28 February 2018

WRL Ref: WRL2017011DJA L20180228 Final

WestConnex M4-M5 Link Independent Groundwater Review Report

Figure 5-10 Pathlines and travel times

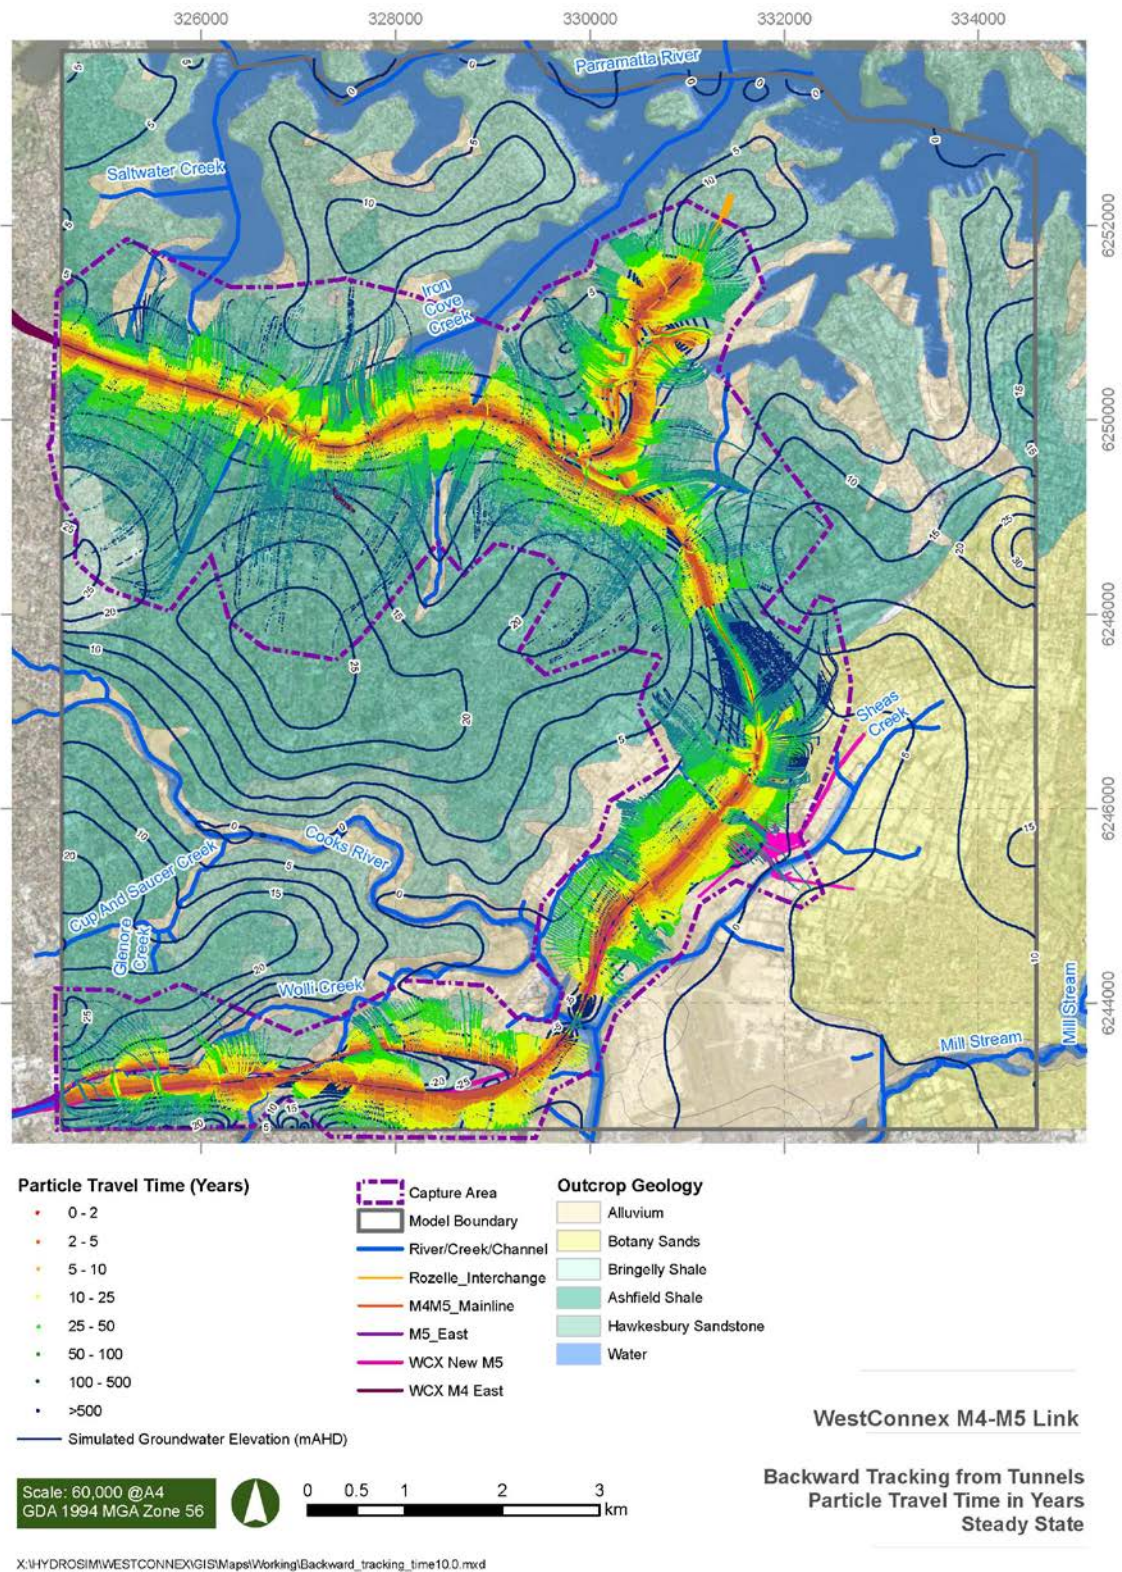
12. The particle track modelling accompanying the supplementary assessment provides suitable information for establishing monitoring locations for groundwater salinity to verify the proponent's assessment of impacts on groundwater salinity.

Figure 6-19 Forward tracking from tidal areas showing particle travel time in years

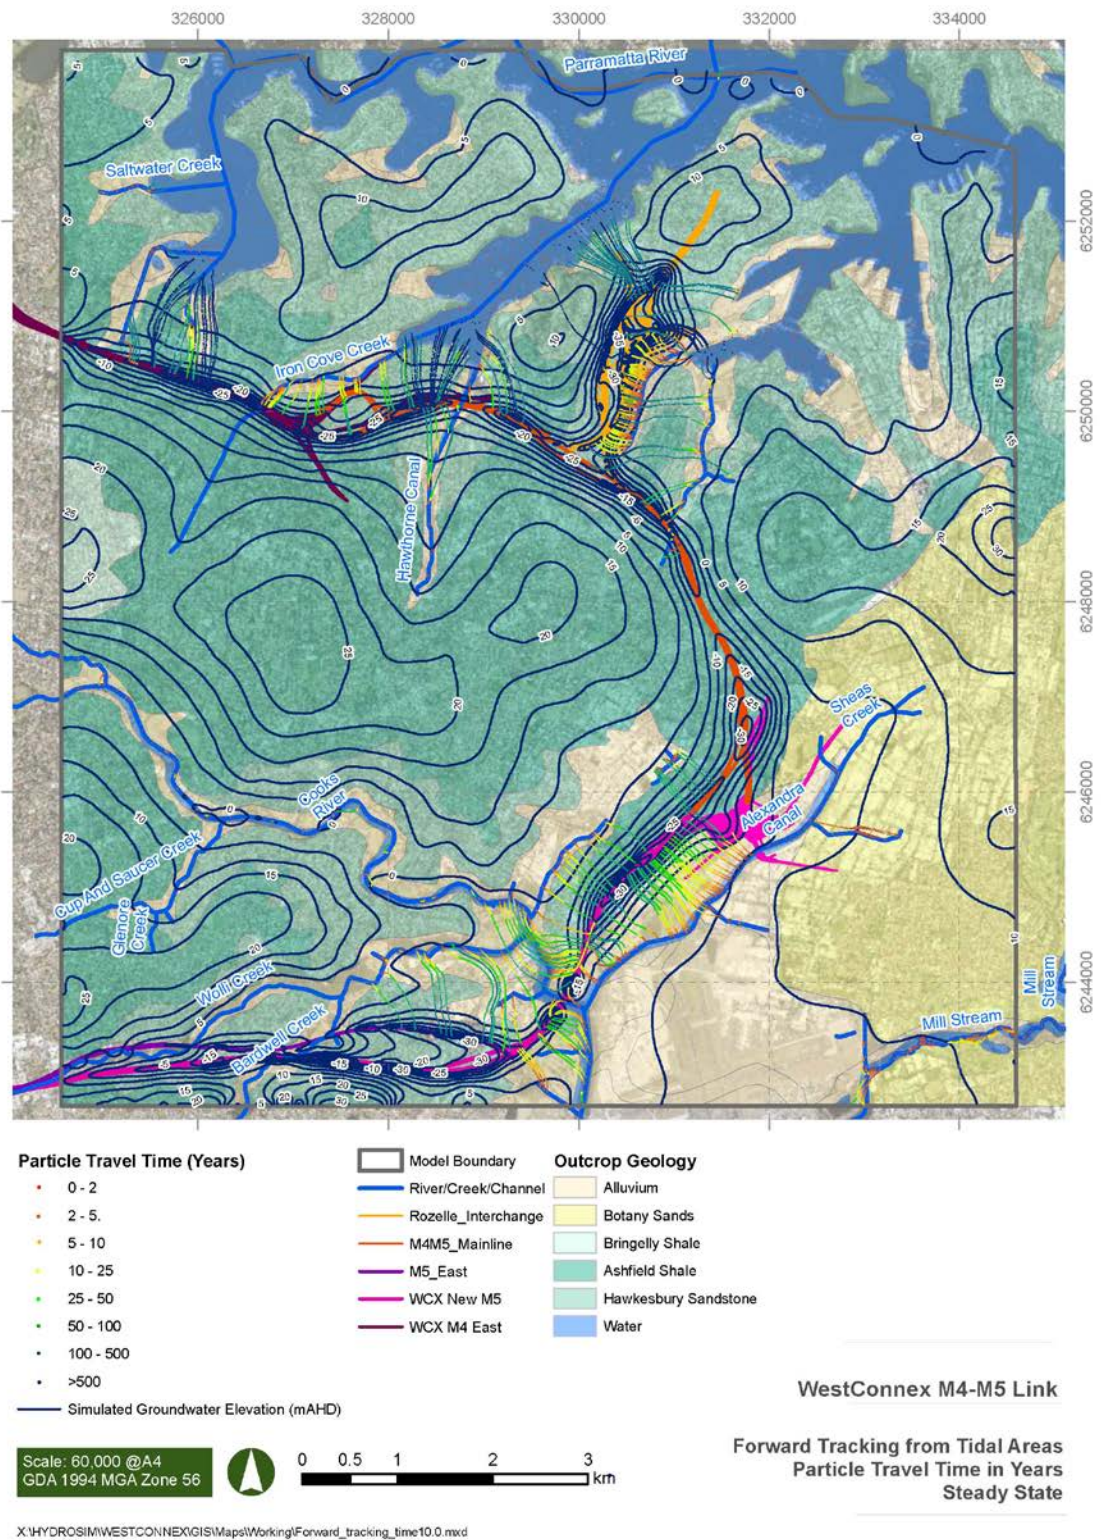
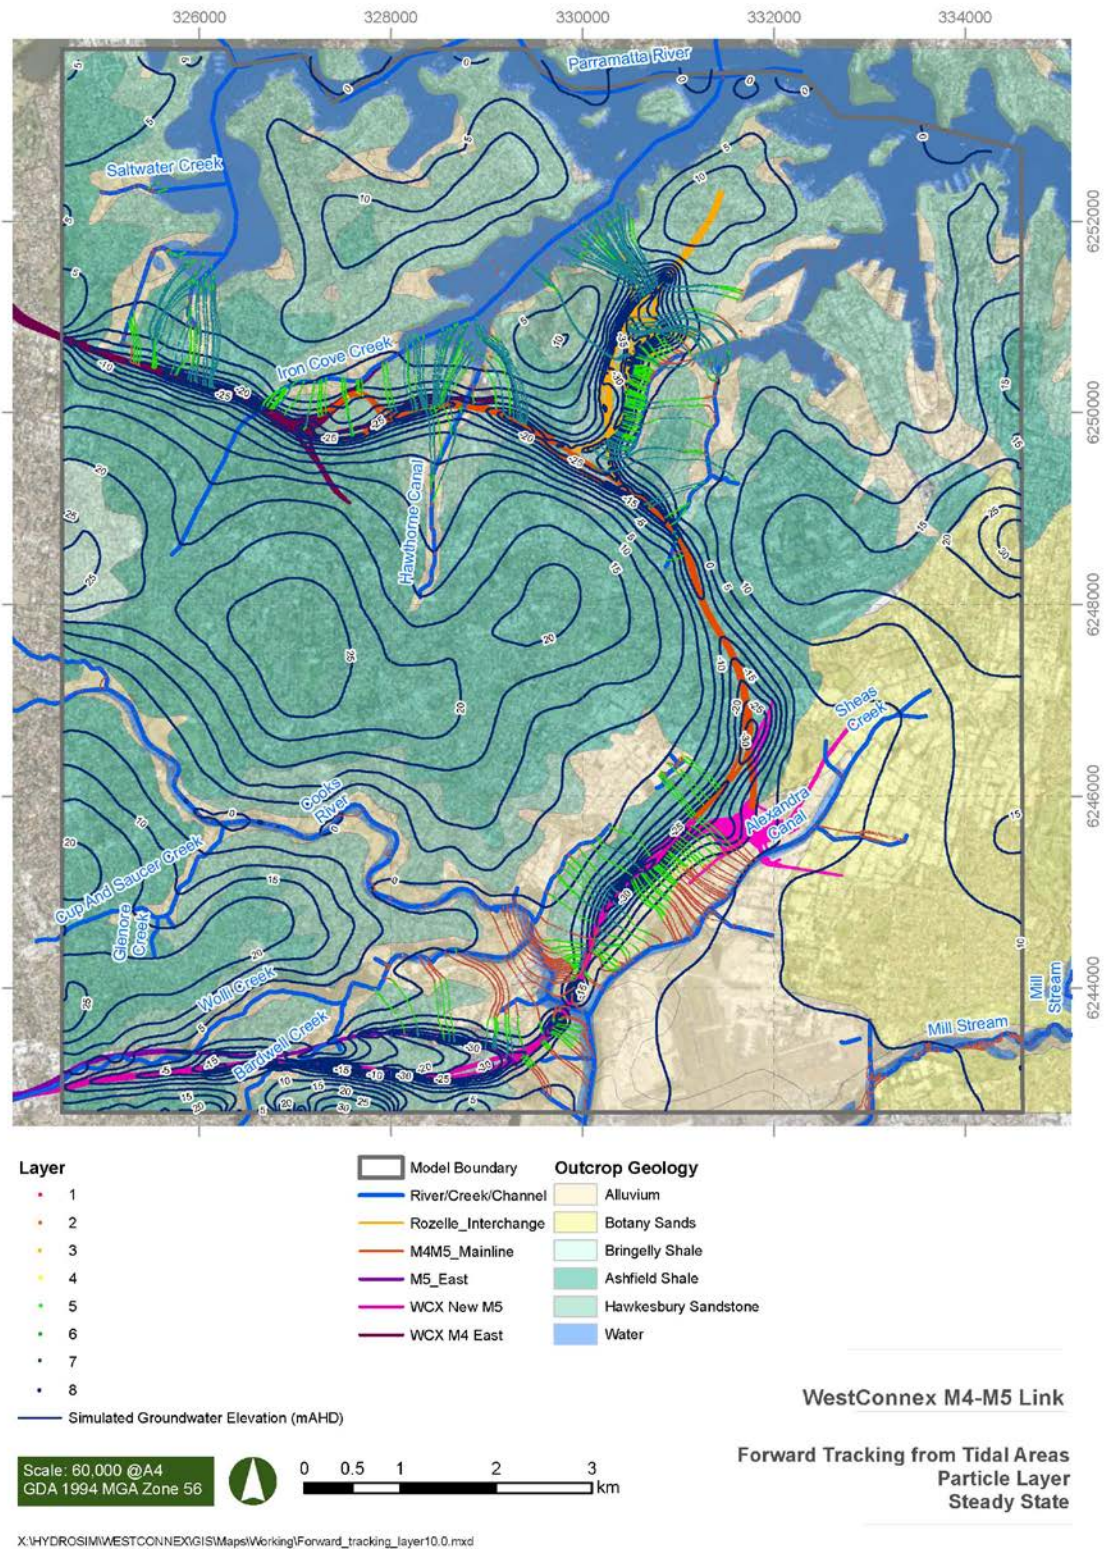
11. The EIS reporting acknowledges that the project may cause some saline intrusion into alluvial and sandstone aquifers between the tunnel alignment and coastal / estuarine water bodies over the very long-term (many decades to centuries) but suggests that the design life of the WestConnex tunnels is only about one hundred years and the groundwater in this area presently has very little beneficial use.

14. A prediction that any part of a groundwater resource would be made more saline does, in the opinion of WRL's reviewer, trigger the more than minimal impact assessment provisions of the *NSW Aquifer Interference Policy 2012*.
